JN 20069

Subject: **Review of Plans**
Proposed New Residence
4304 E Mercer Way
Mercer Island, Washington

As required by City of Mercer Island, we have completed a general review of the geotechnical aspects of the plans for your new residence. For our review, we were provided with the architectural plans (McClellan Architects; October 25, 2021), structural plans (Gary Gill; September 21, 2021), and civil drawings (Civil Engineering Solutions; February 23, 2022).

A1.1

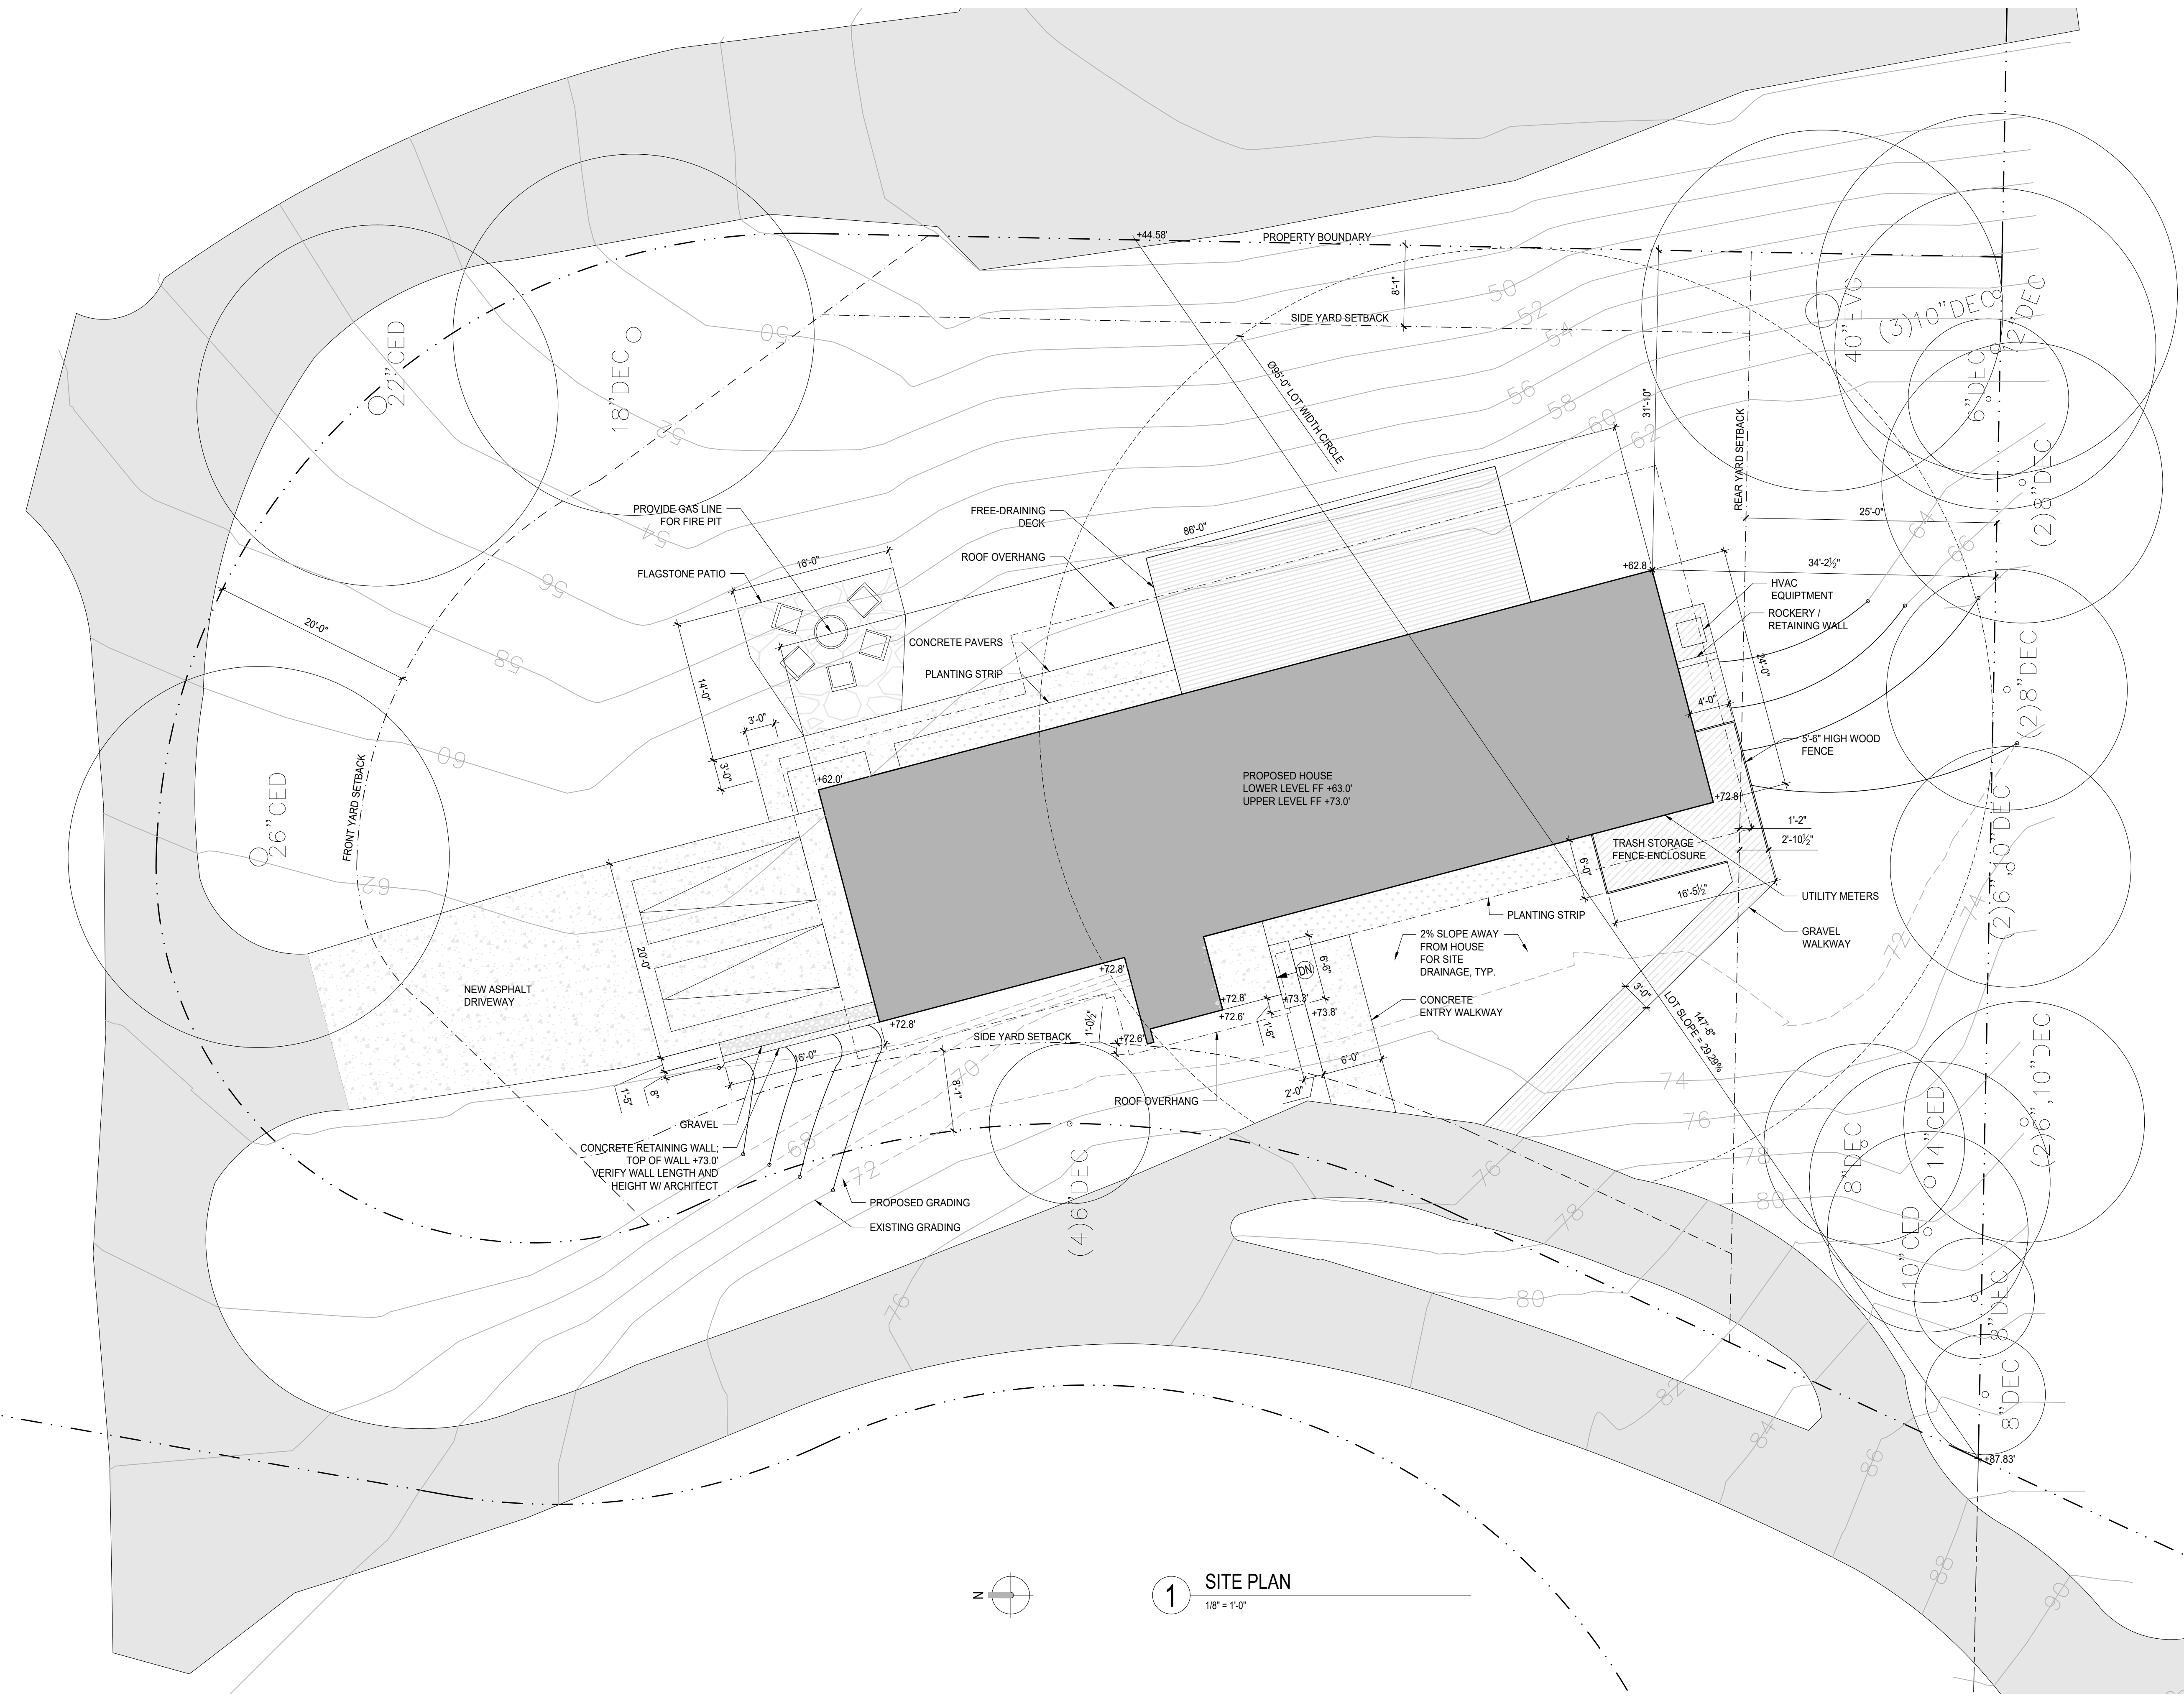
Architectural sheets A1.1 and civil sheet C2.0 show an on-grade patio off the northeastern corner of the new house. It is important that this patio be constructed without filling on the moderately- to steeply-sloped ground, as that would require an engineered retaining structure founded on dense soil.
